8<sup>th</sup> February 2021

**Reference: M25 Junction 28 Improvements representation**

100

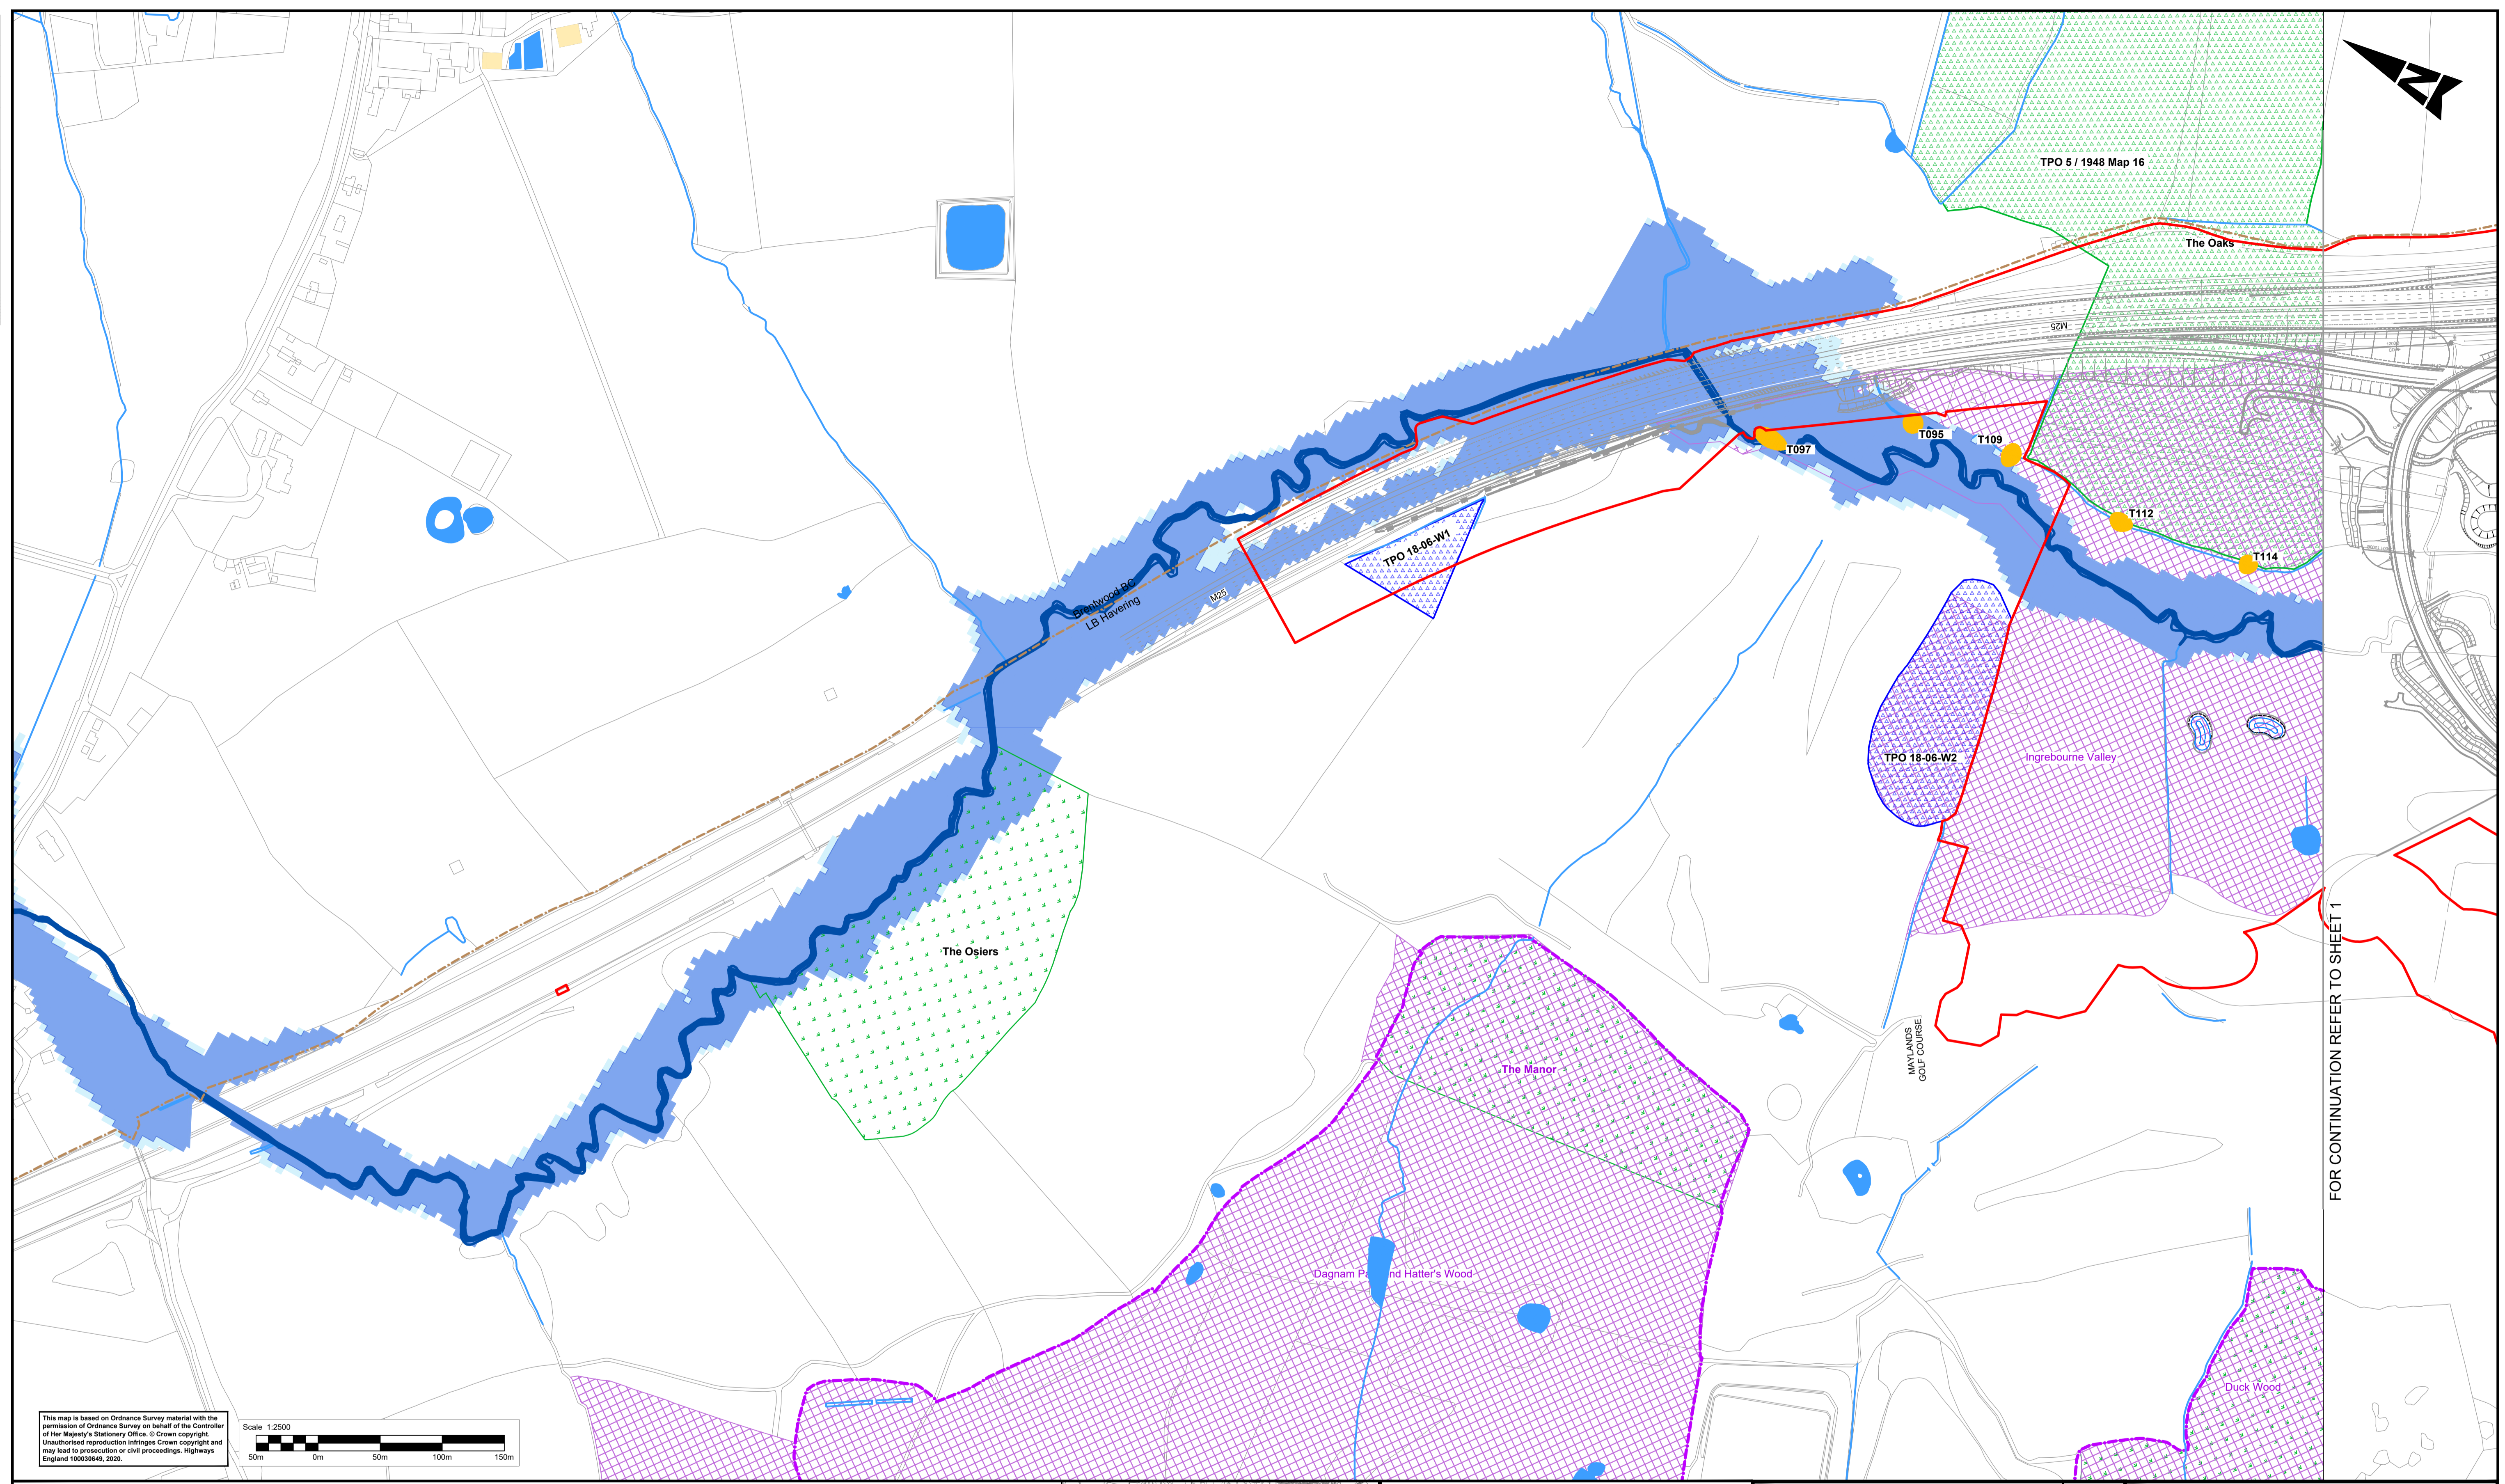
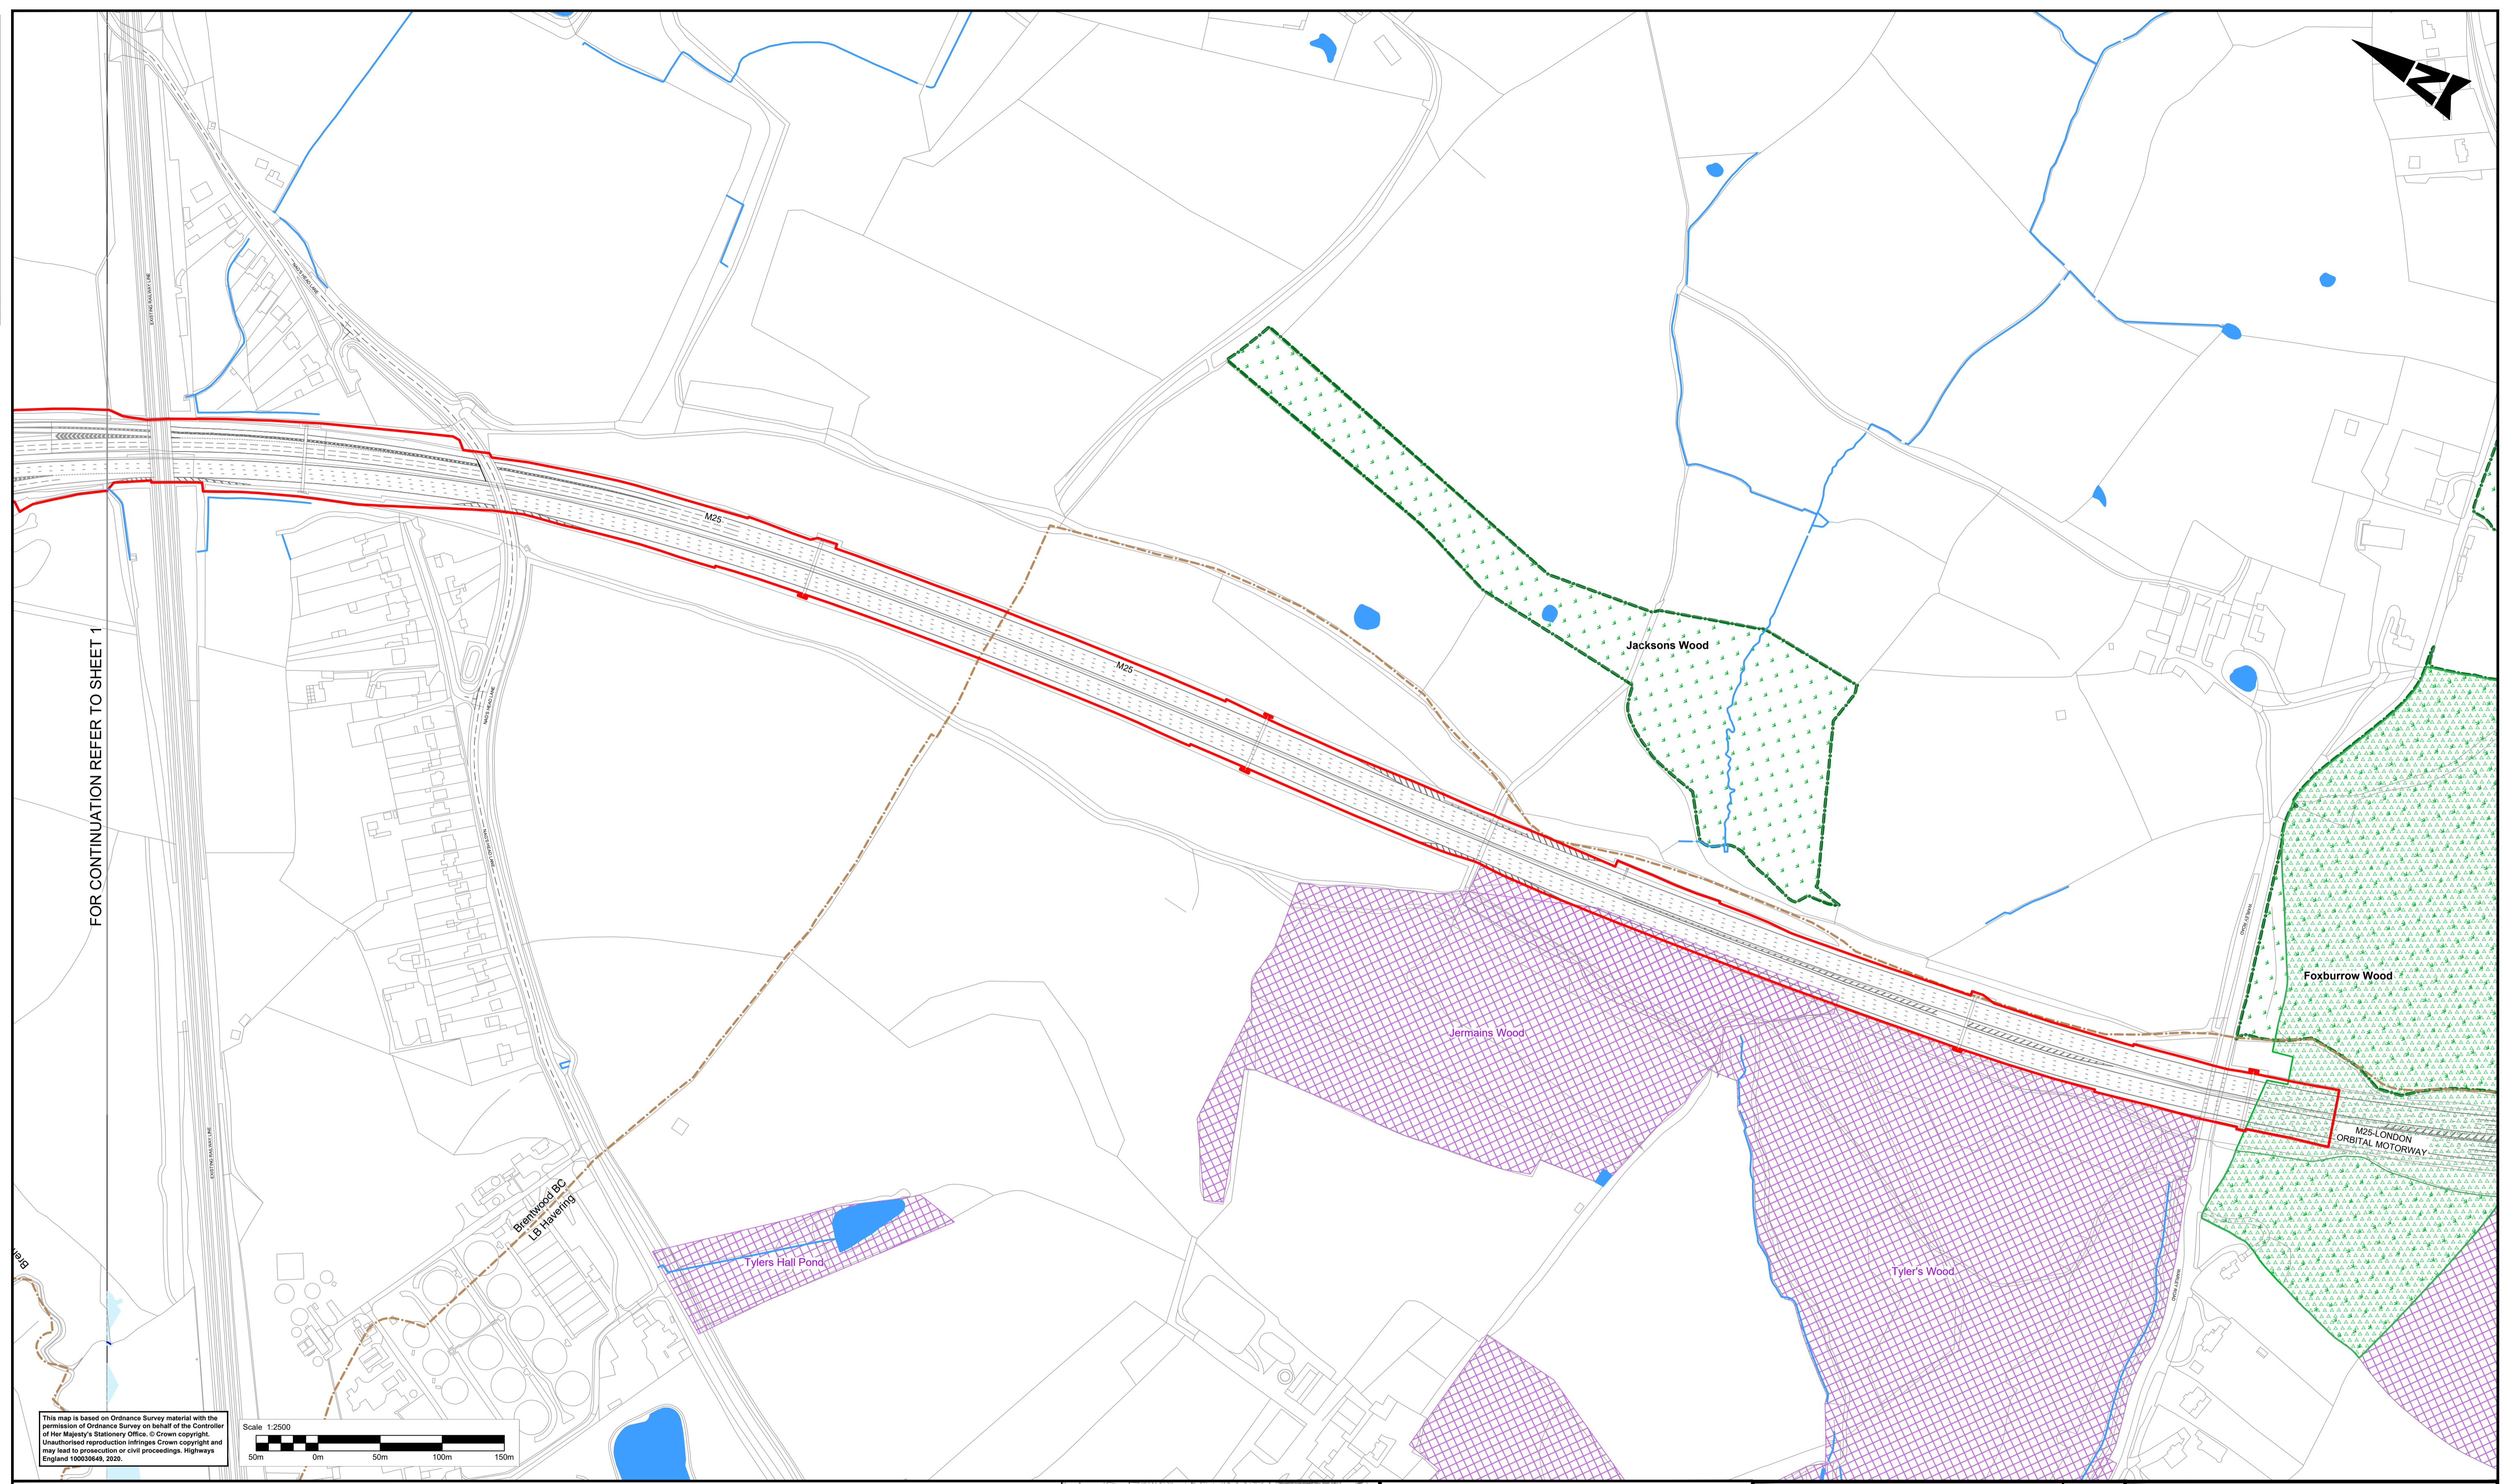
The proposed improvements to the M25 Junction 28 will result in potential impact to several veteran trees identified within the Arboricultural Impact Assessment [Reference: APP-063] either through direct loss of specimens in order to facilitate construction (T021A and T074) or through damage to the root systems via encroachment of root protection areas (RPA).

It is essential that no trees displaying veteran characteristics are lost or damaged as part of the project. Any loss of veteran trees would be highly deleterious to the wider environment of veteran trees within close proximity, which may harbour rare and important species.

In summary, the Woodland Trust requests that all trees displaying veteran characteristics are retained and adequately protected with a Root Protection Area in line with Natural England's Standing Advice.
